**Jacfin Pty Ltd - Submission on ESR Horsley Logistics Park
State Significant Development Application 10436
Site: 6 Johnston Crescent, Horsley Park**

We refer to State Significant Development Application 10436 (**Application**), by which ESR Developments (Australia) Pty Ltd (**Proponent**) seeks approval for the development of a new industrial warehouse and distribution precinct, including the construction and fit-out of six warehouses, on-lot stormwater, infrastructure and services (**Development**) on the Site.

RE: Objection to State Significant Development Application ESR Horsley Logistics Park

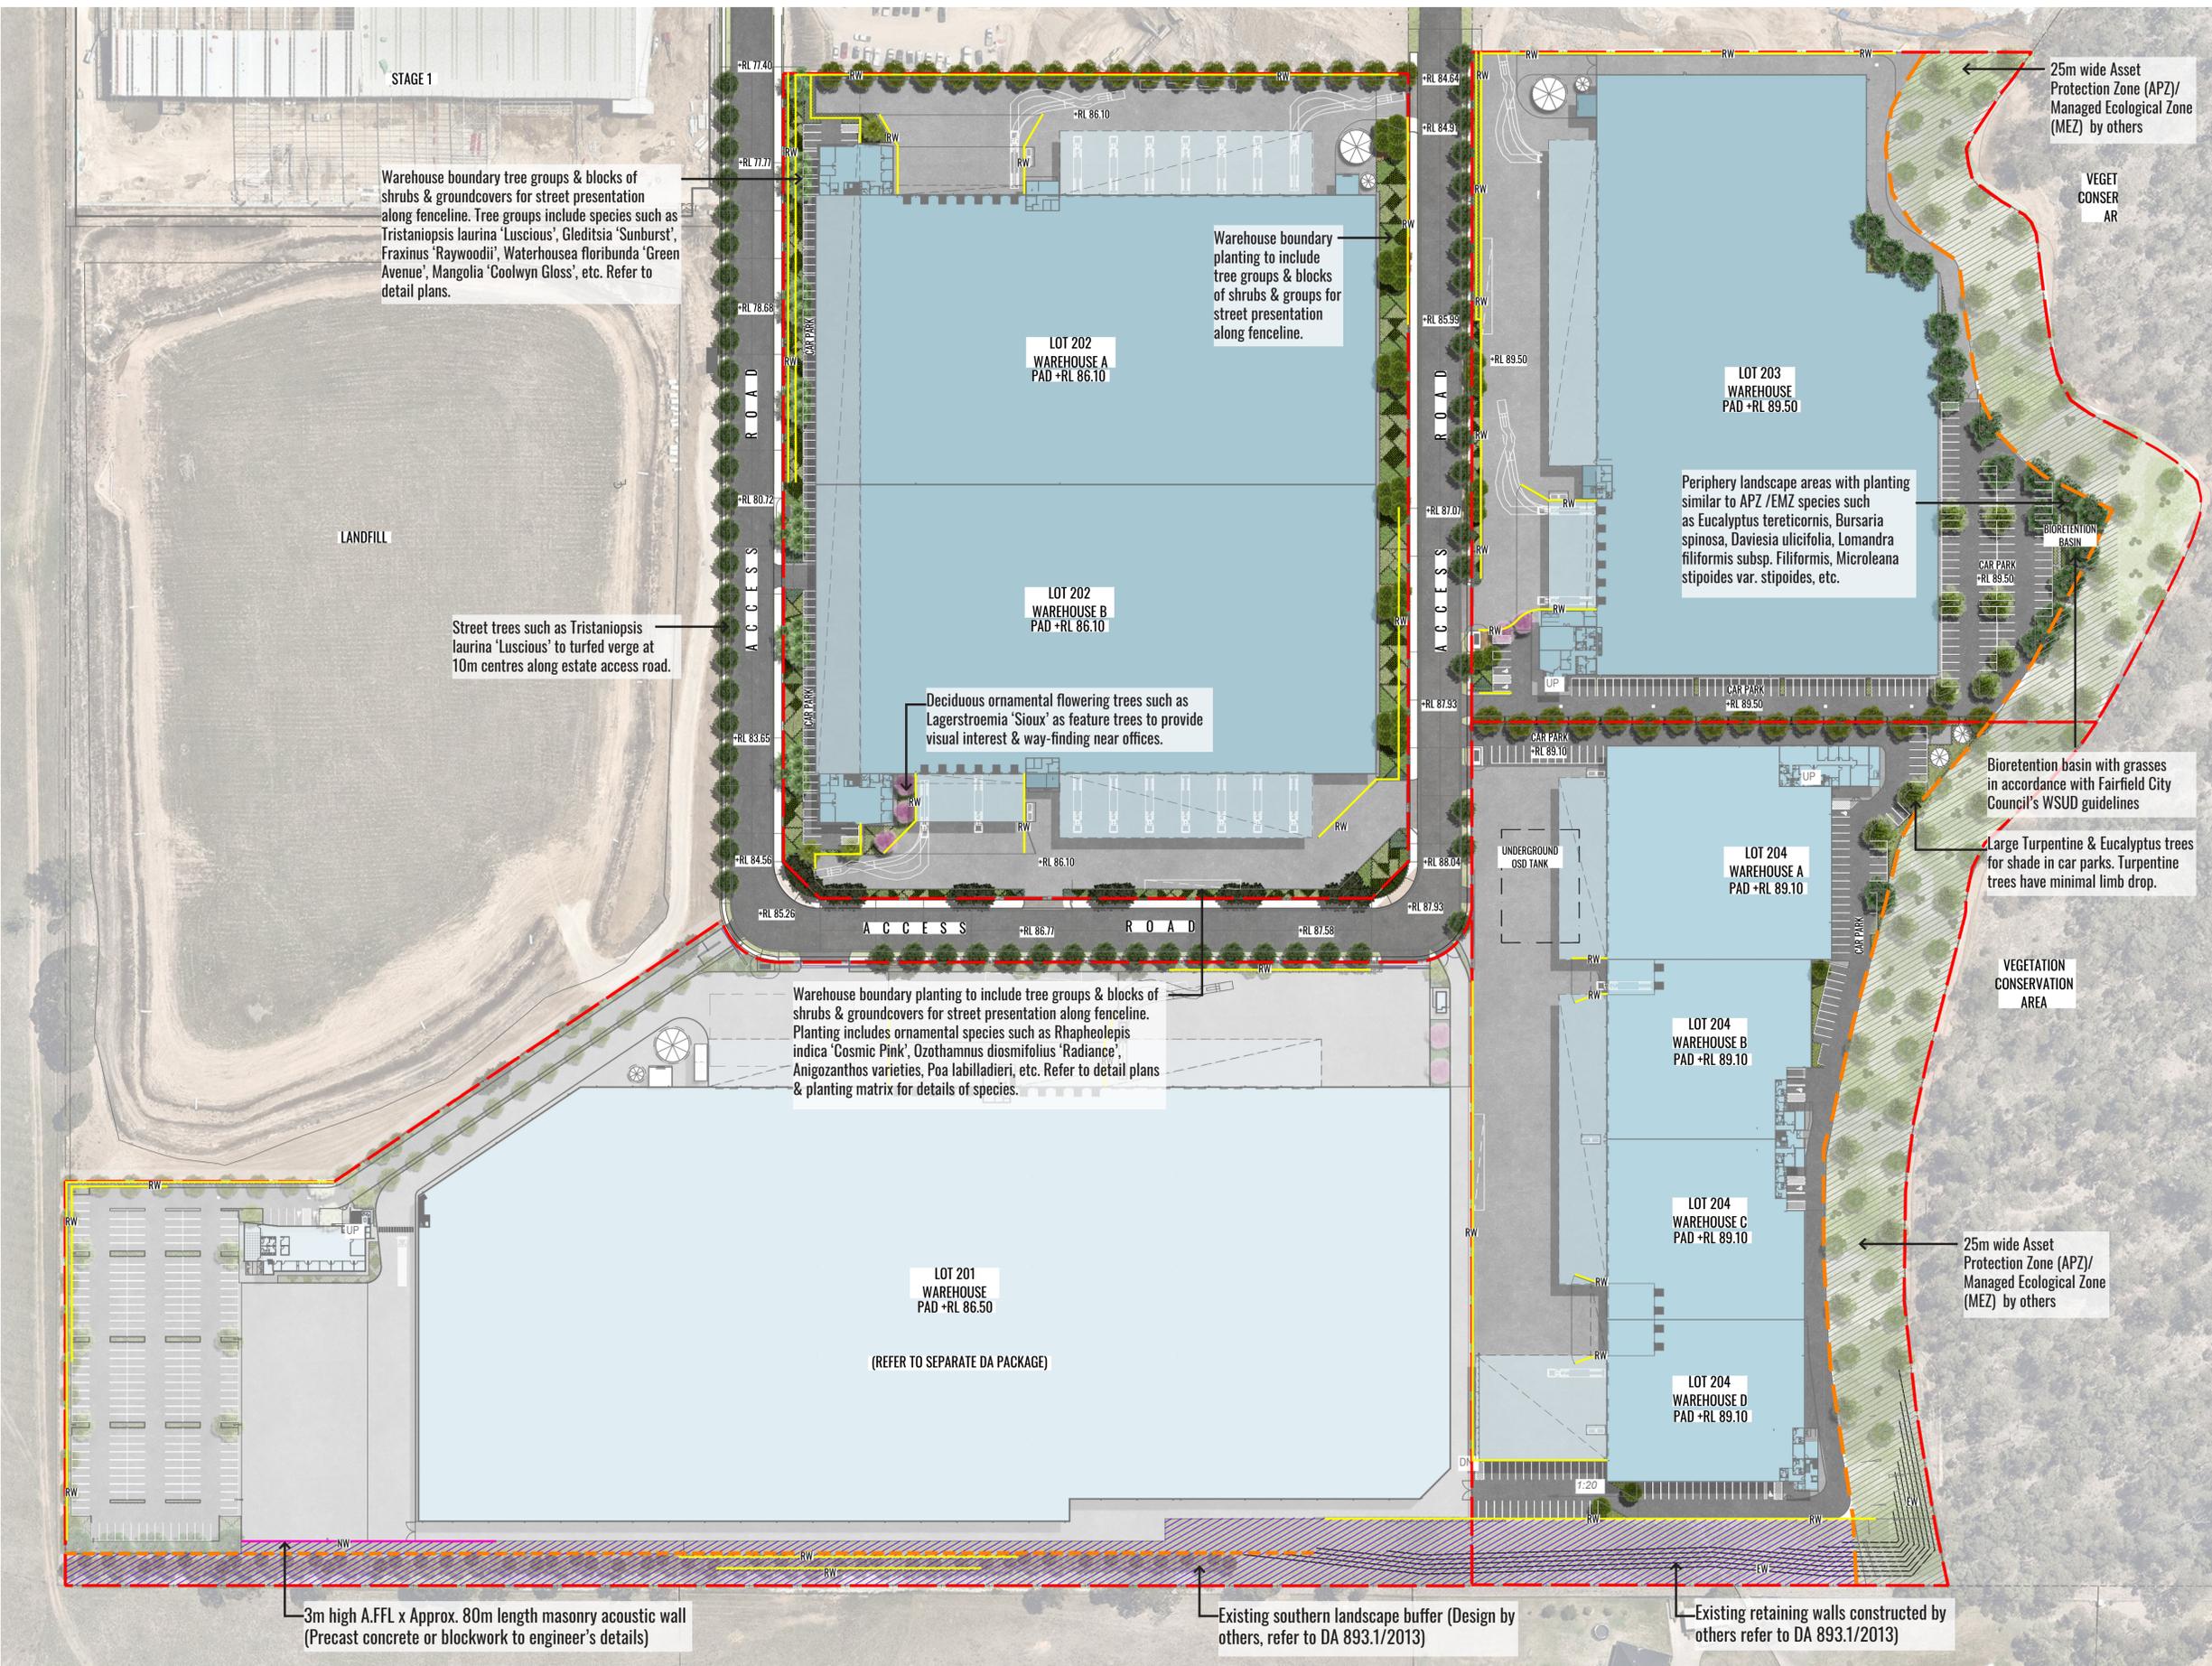
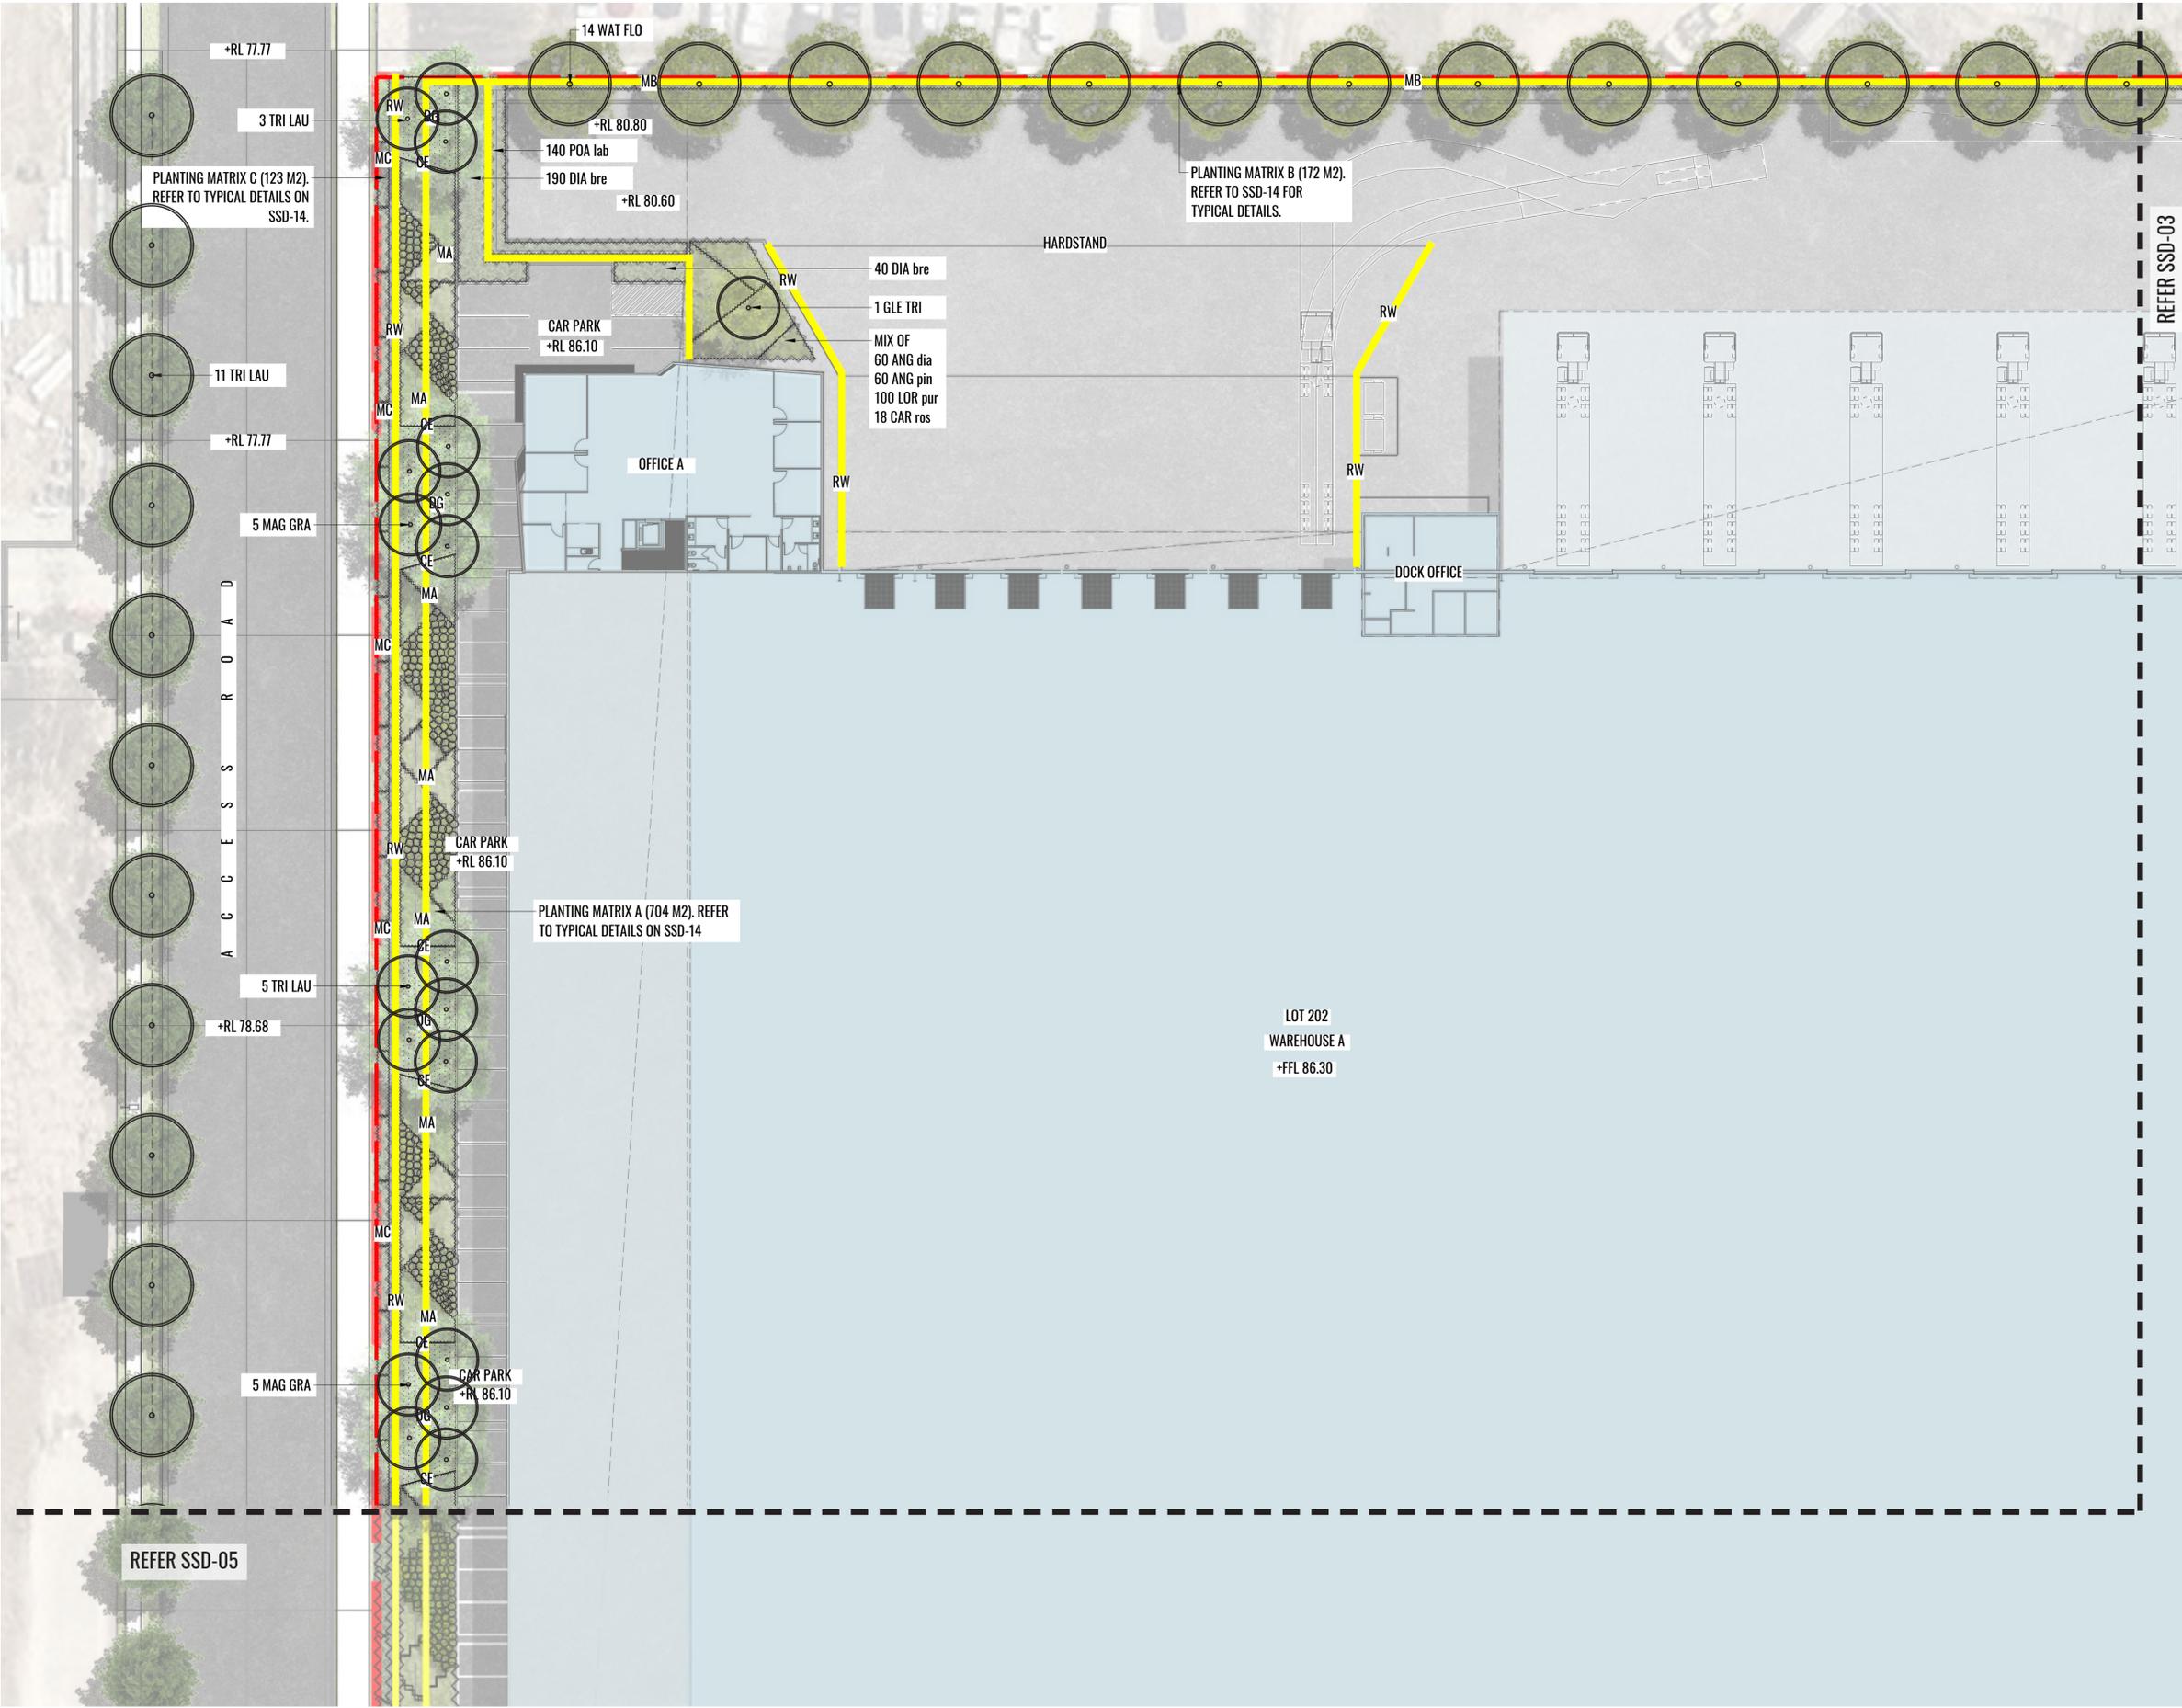
The Landscape Plans prepared by Geo Scapes (Drawing No. LDA-01 Revision C) show the proposed setback, however outline that "Southern landscape buffer (by others)". The landscape plan suggests that the landscaping of this buffer is provided under DA893.6/2013 and therefore does not need to be shown on this application. The maintenance of the landscaped setback will be the responsibility of ESR and should therefore be detailed on the EIS and be suitably conditioned. The EIS should also consider the existing and proposed height of the landscaping at the time of construction noting Commissioner Morris's comments in the judgement [70]:

The proposal needs to be amended to show a greater planted setback in line with the conditions of the Court. Furthermore the landscaping for the buffer needs to be considered as part of this EIS in the context of the buildings proposed to ensure the landscaping is dense and large enough to properly screen the proposed development.
